RE: 6/2023/0444/COND – Land to the North-East of King George V playing fields, Northaw Road East, Hertfordshire, Cuffley, EN6 4RD

Thank you for consulting us on the above application received on 10 May 2023, for the submission of details pursuant to condition 6 (surface water drainage), on planning permission S6/2015/1342/PP for the residential development of up to 121 dwellings, associated infrastructure, and a change of use from agricultural land to an extension of the King George V playing field.

We **Object** to this applicaiton in the absence of an acceptable supporting information in relation to discharging condition 6, and note that condition 19 is related. An amended flood risk assessment with modelling information has been provided, however, the following issues in relation to condition 6 still stand.

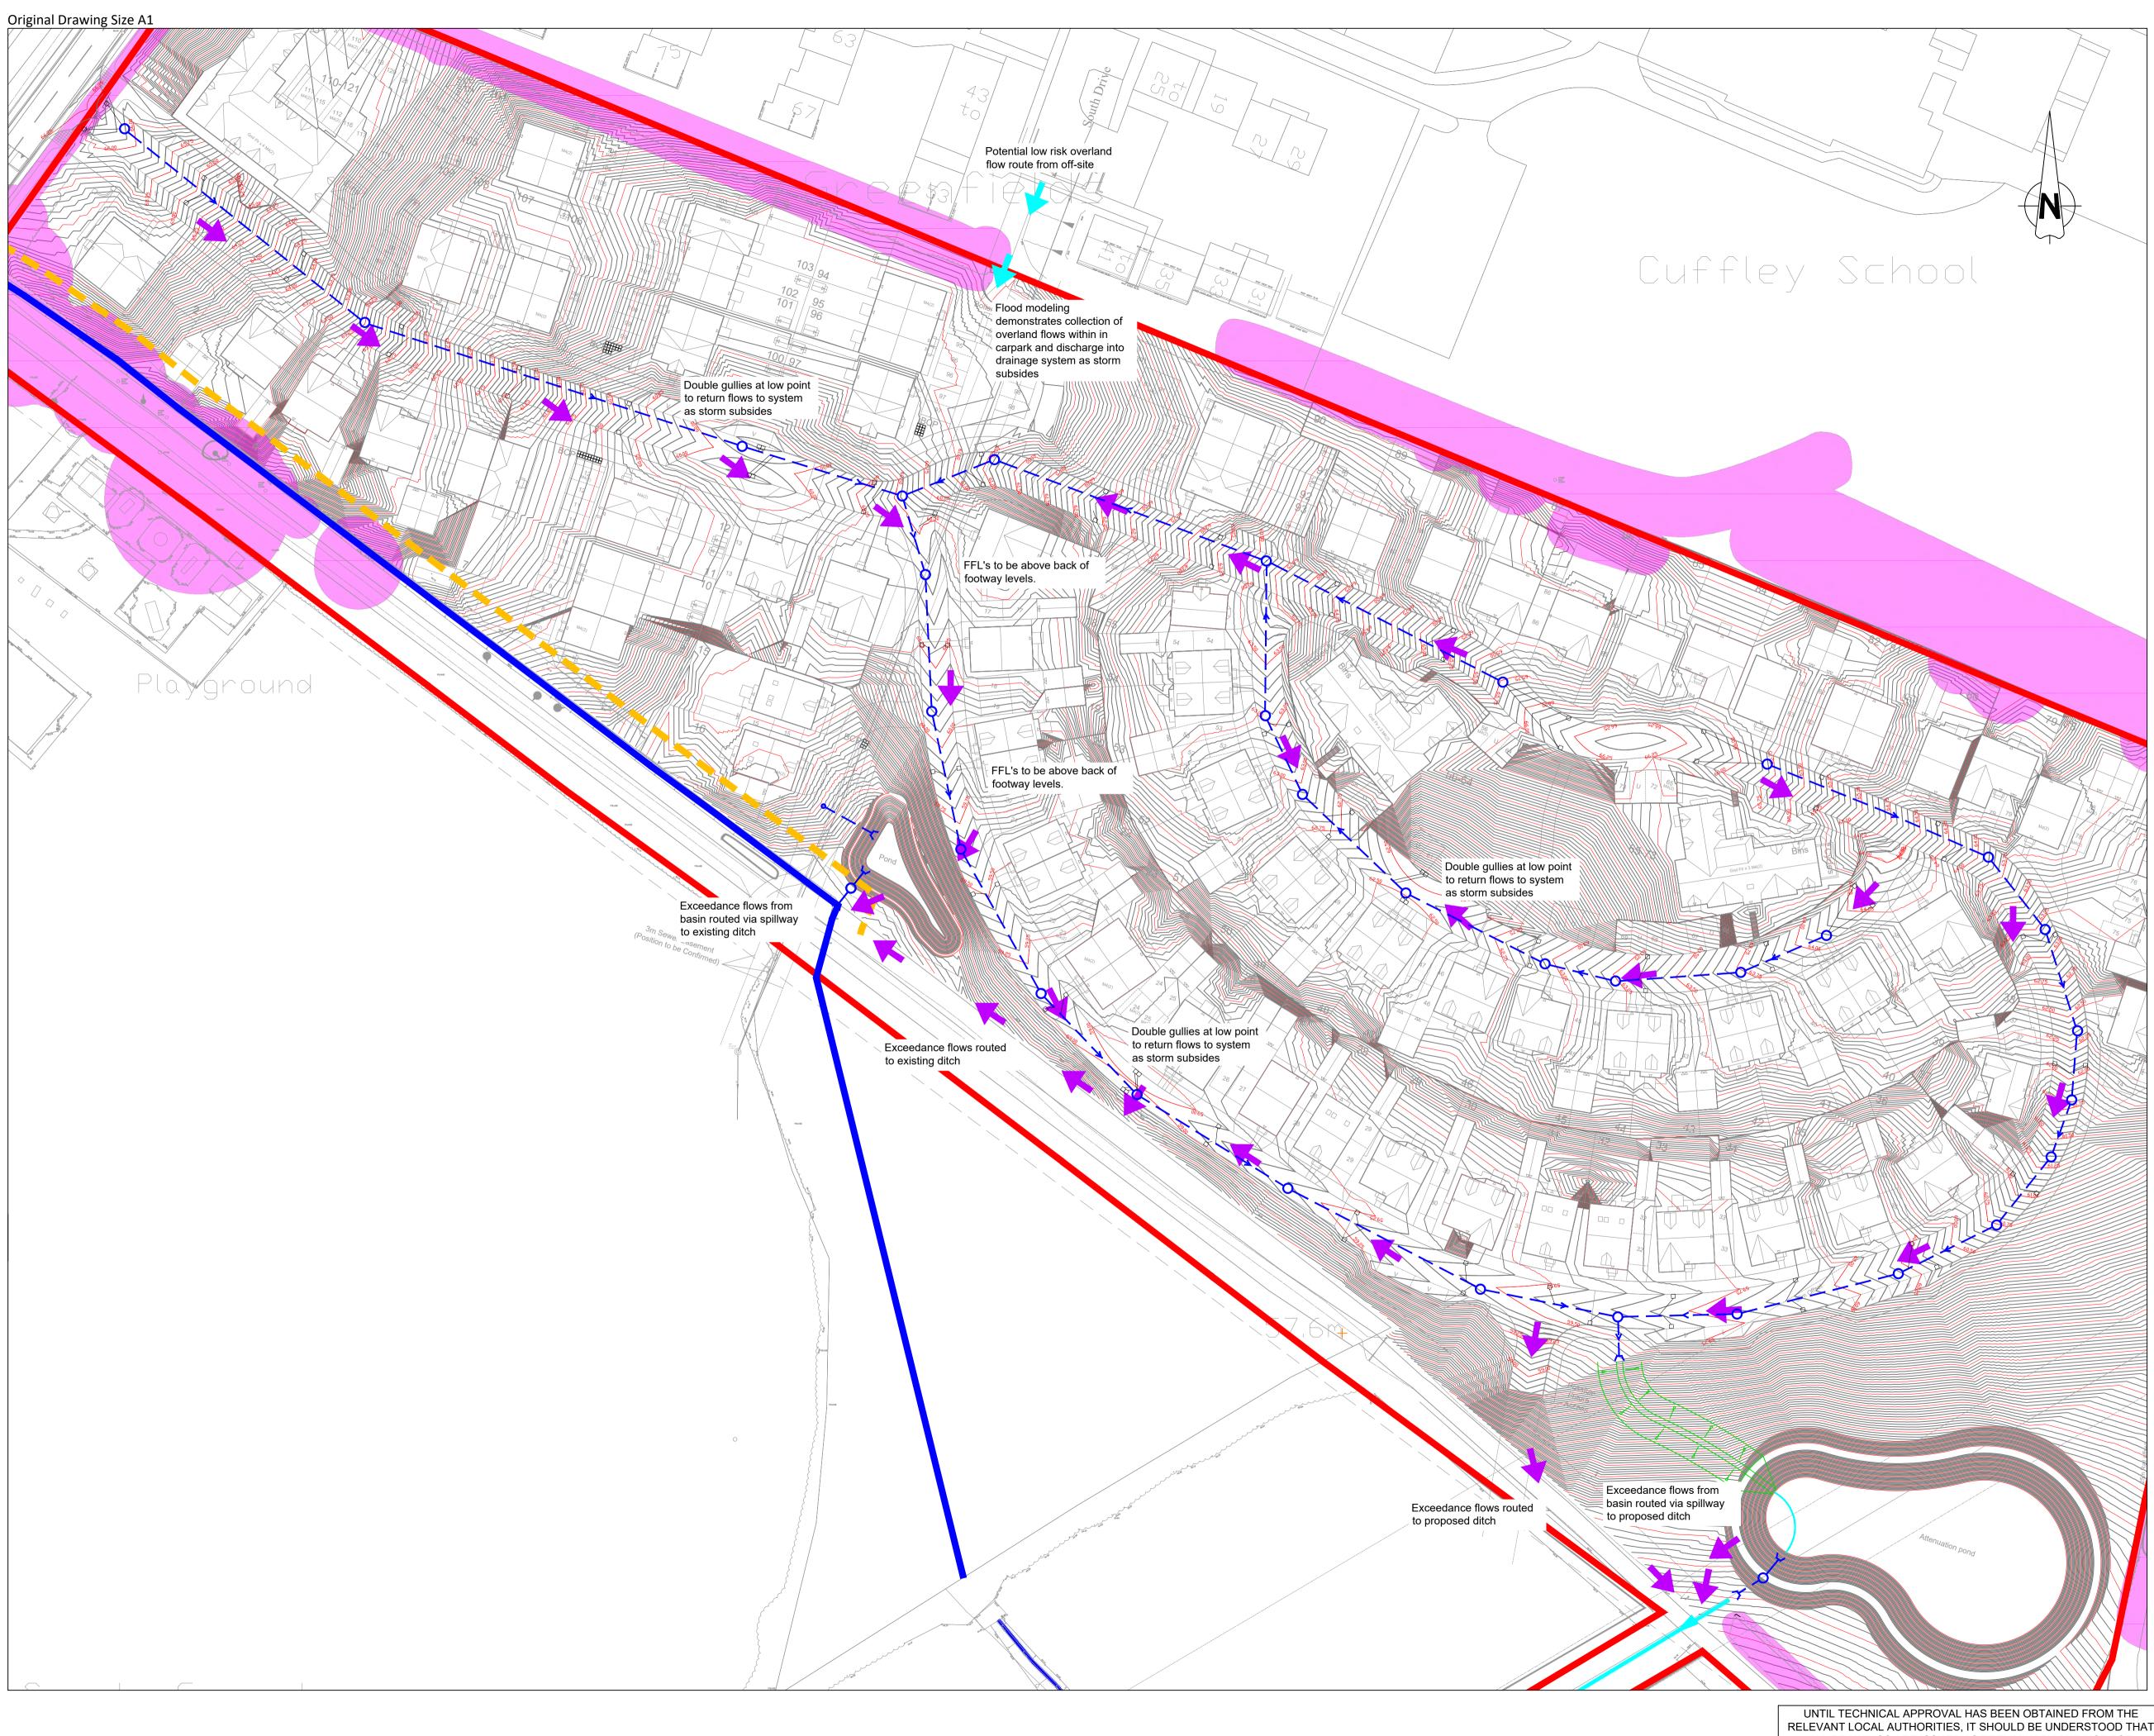
We also require Finished Floor Levels to be added to drawings (10929-500-001) and (10929-500-004) to ensure that there is sufficient freeboard (300mm) above any above ground flooding.

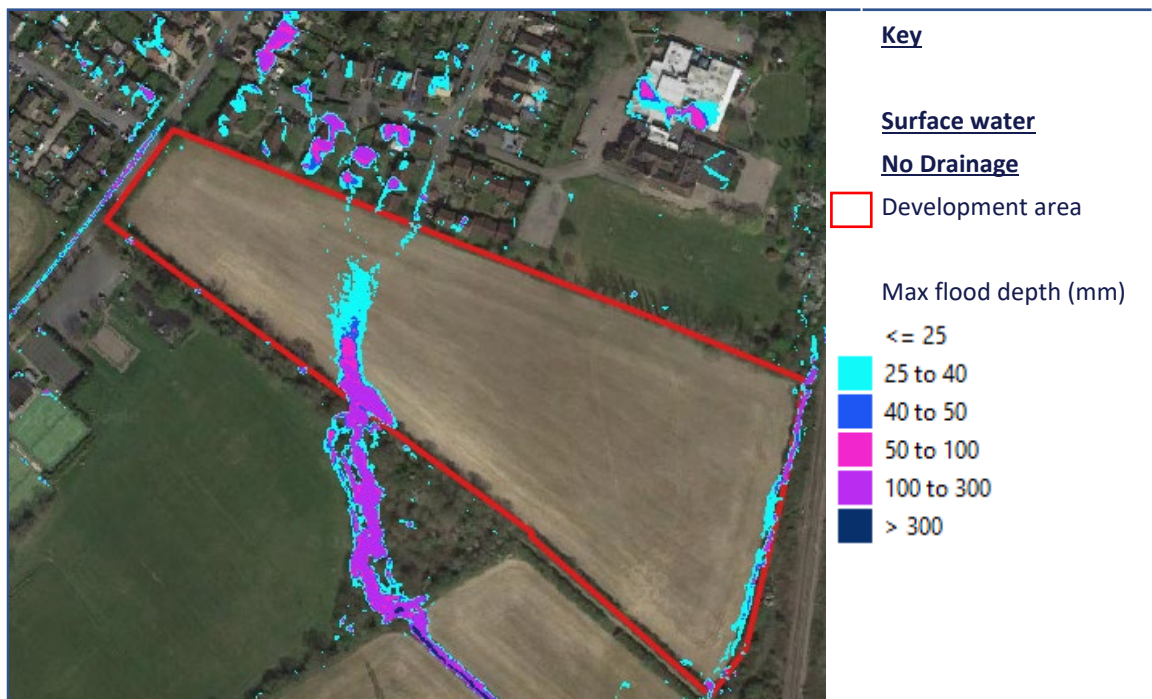
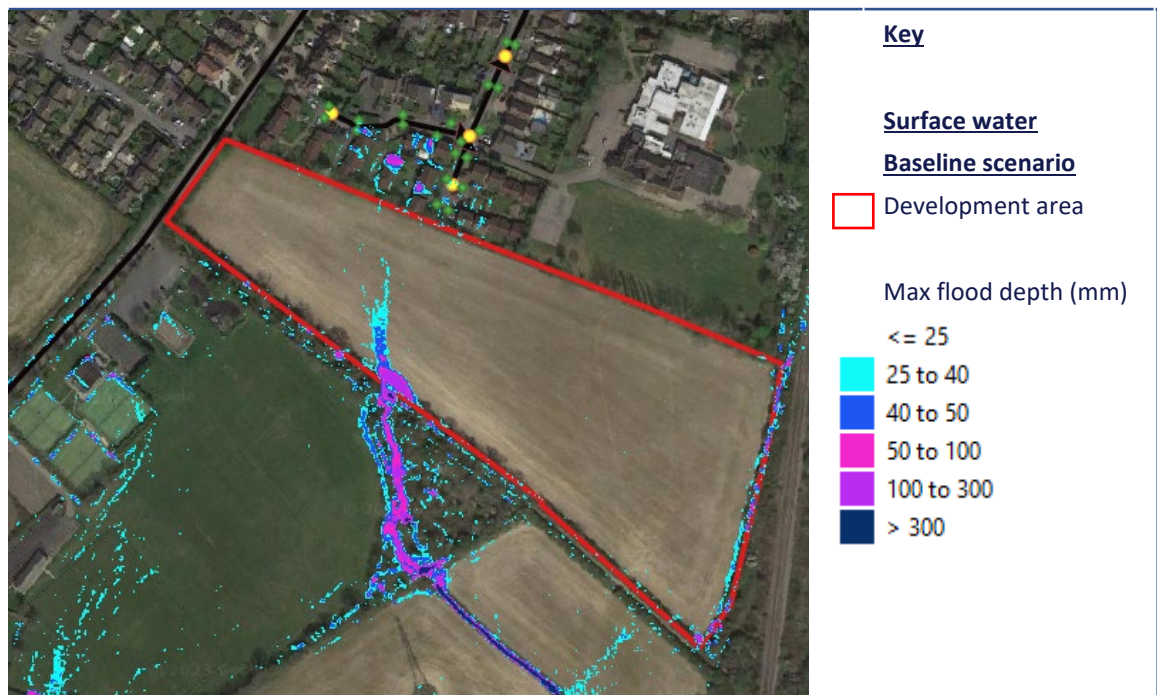
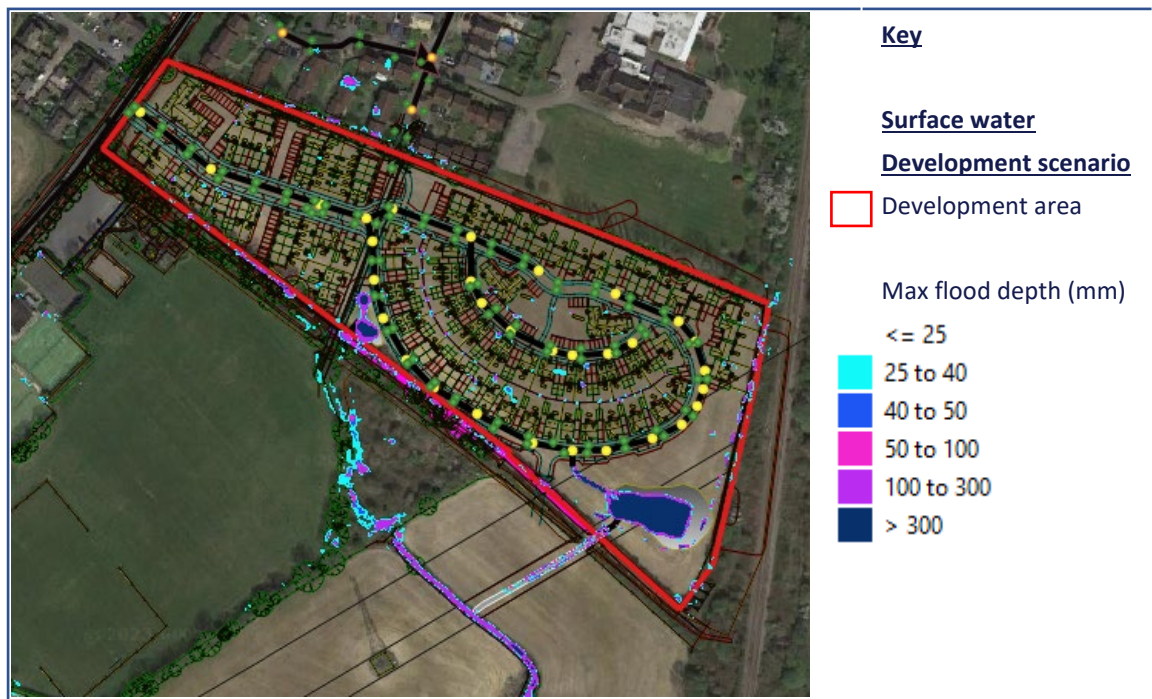
- Provide a comparison of EA surface water maps alongside the surface water model baseline scenario. Surface water flooding depth difference maps between pre and post development should be provided to illustrate comparisons to help verify results and identify where flood risk is reduced or increased. Appropriate key with labels should be included.

Status		Status Date
Approval		June 2022
Drawn	Checked	Date
HG	DC	16.06.22
Scale	Number	Rev
1:500	10929-500-001	D
0 10 20 30 40 50		
METRES

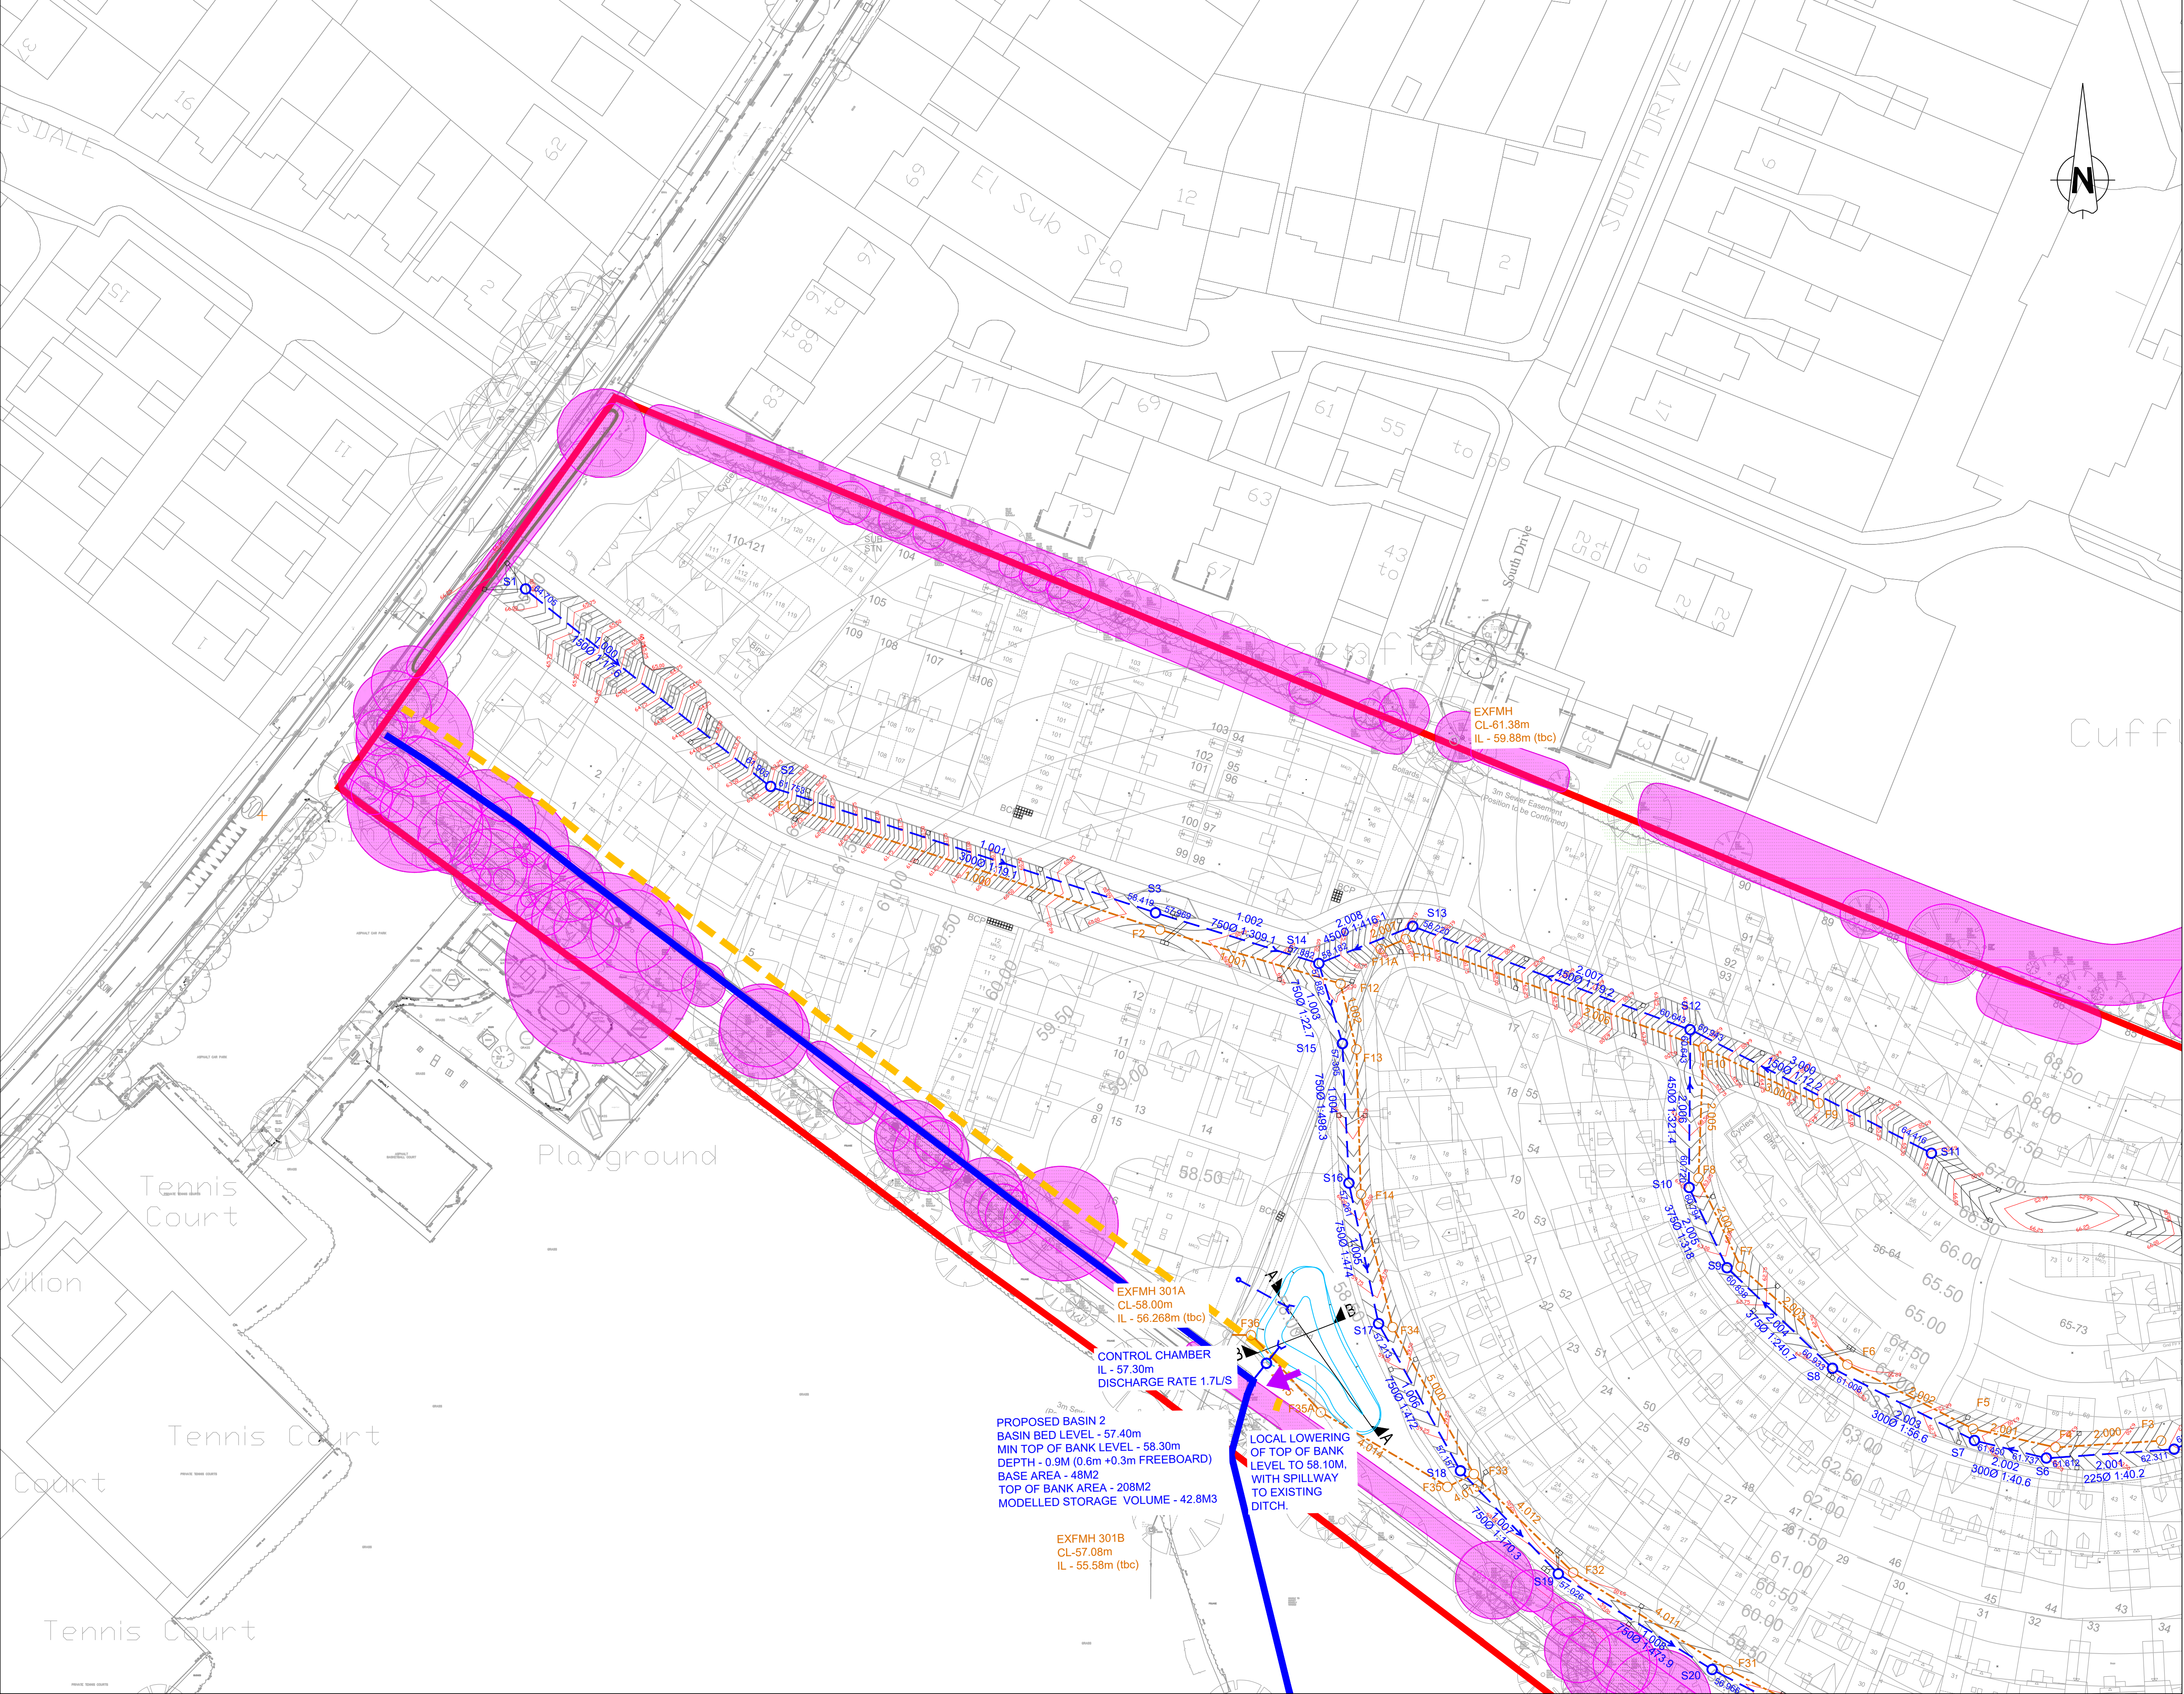
The Drainage strategy drawing provided (10929-500-001) labels several drainage features including the outfall ditch and attenuation basins 'proposed', with 'proposed storage' attached. At this stage of planning all SuDS features and drainage outfalls should be 'Final'. We require storage volumes for the attenuation basins to be 'final', in order to satisfy concerns in regard to the overland surface water flow path risk.
